Fire Marshal Division

**Re: Pleasant Union Christian Church
2164 Neills Creek Road
Lillington, NC 27546**

Application Number BCOM1902-0001

SHEET NUMBER  
**A-5.1**

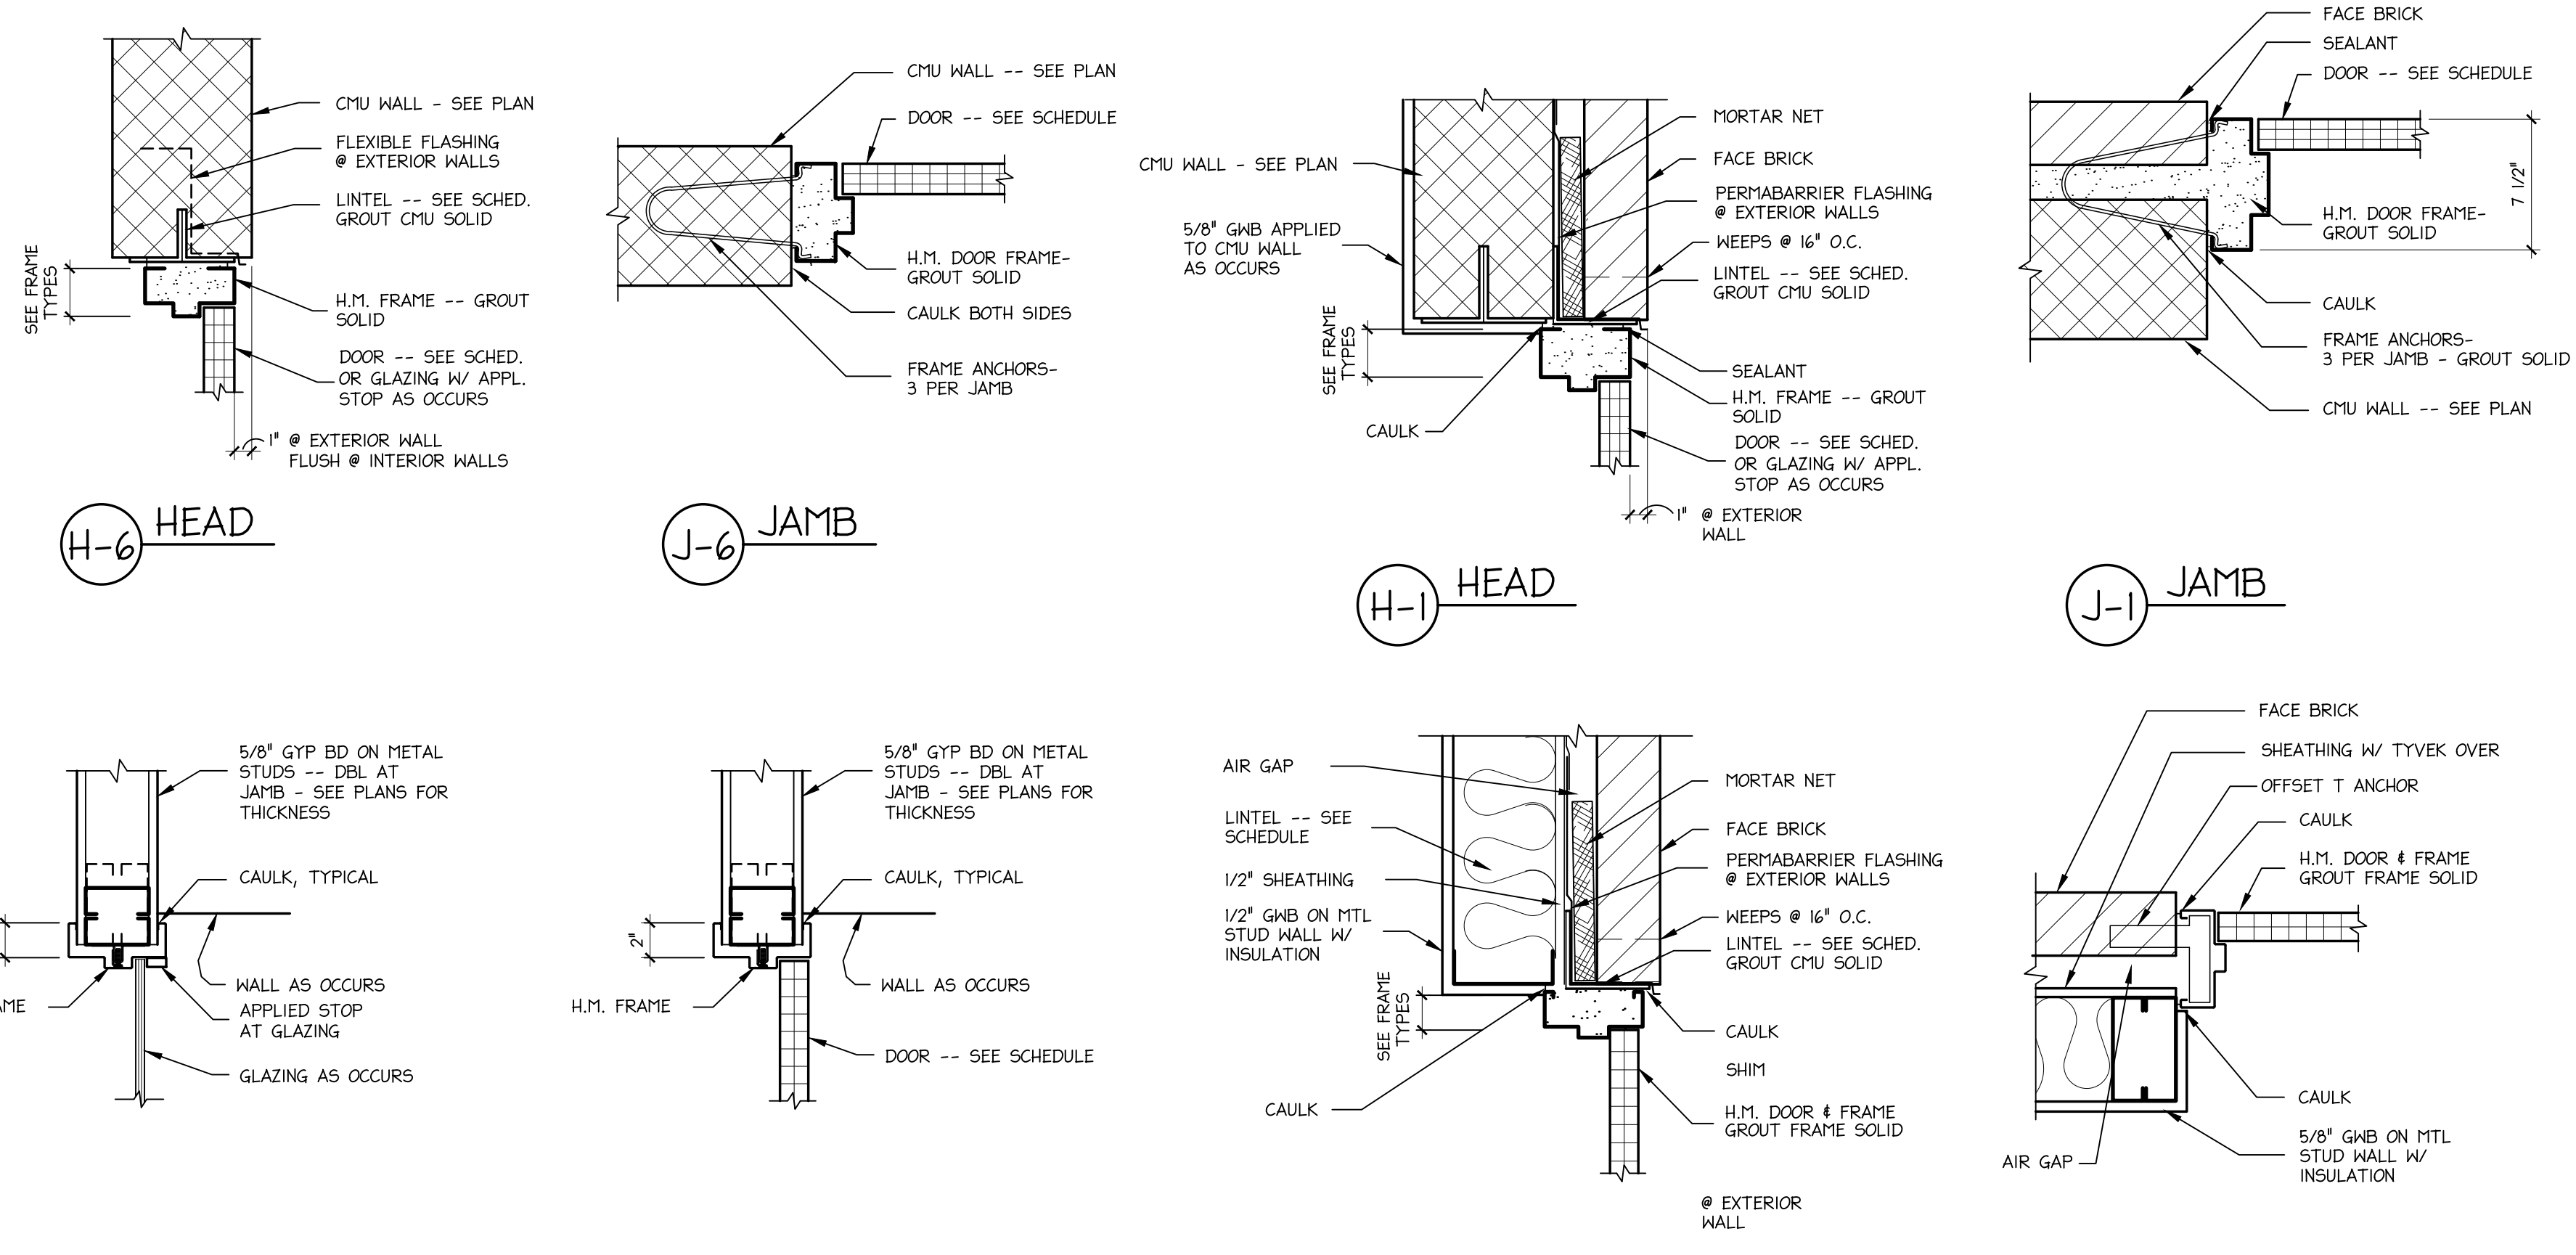
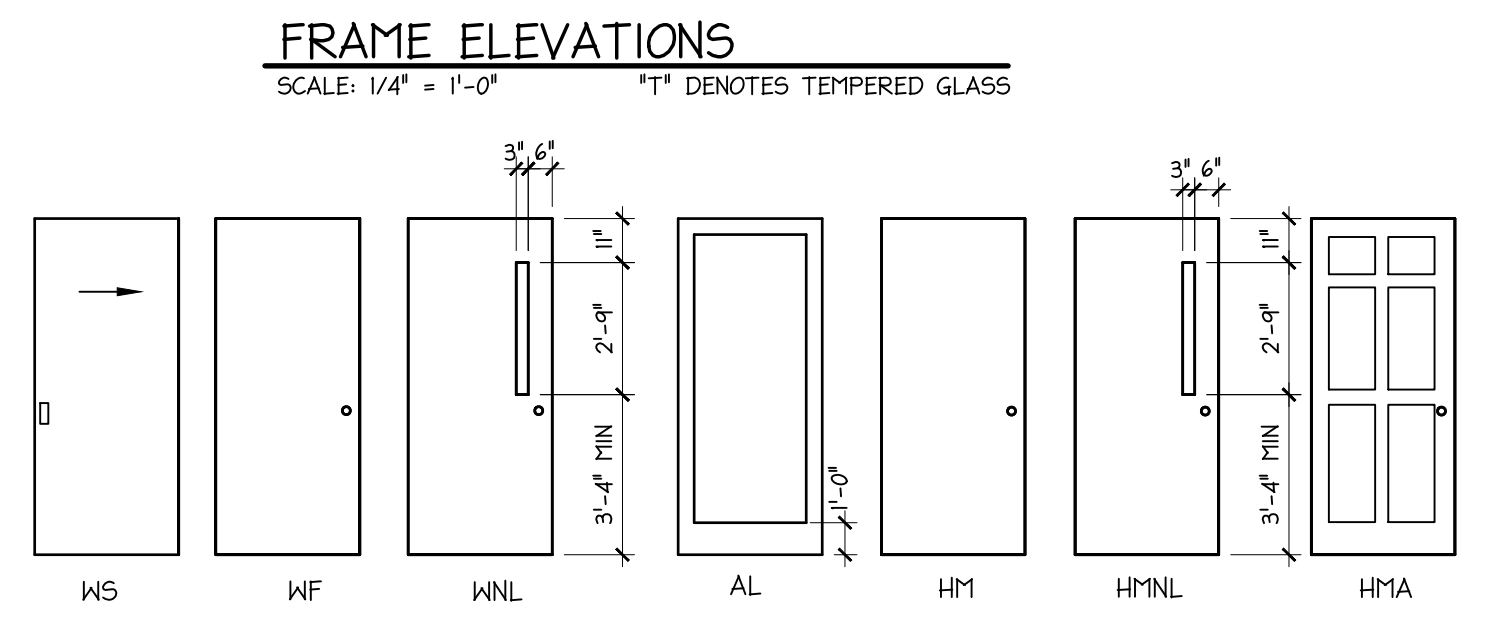
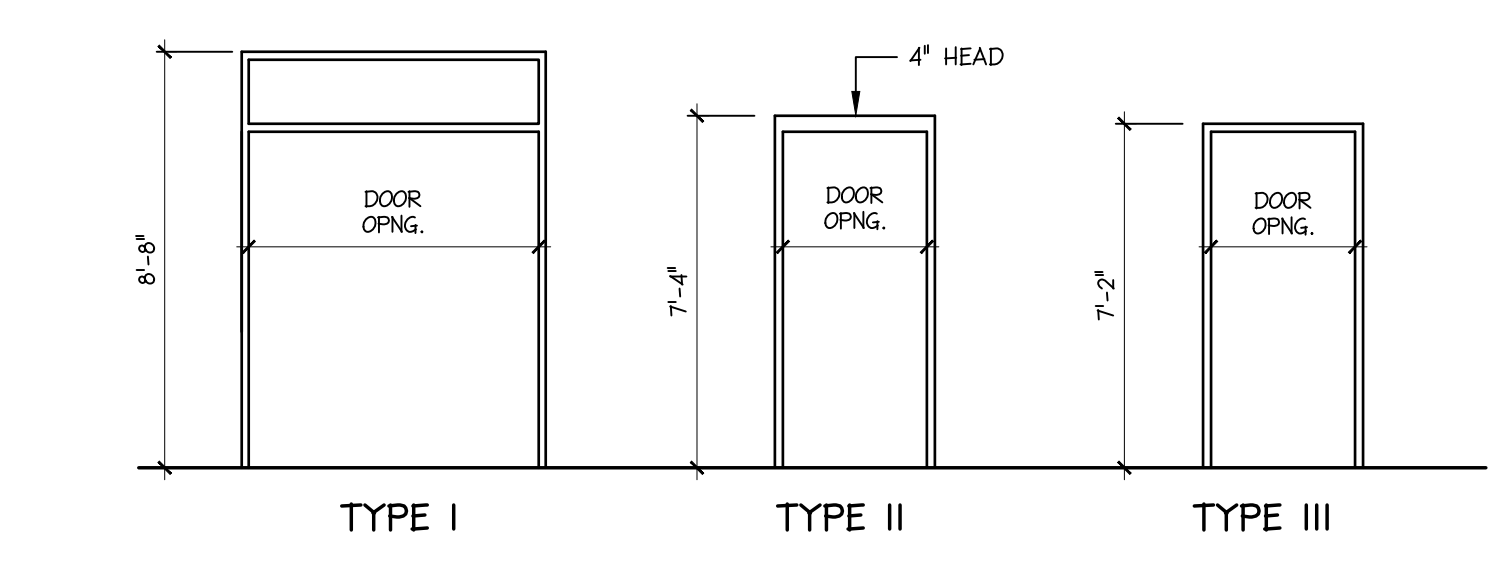
- **1008.1.10 Panic Hardware**
 - UL 305 listed panic hardware is required on exit doors serving a room/space with an occupant load >50, also indicated on Building code summary. Panic hardware is not included on door schedule sheet B8 of Drawings.
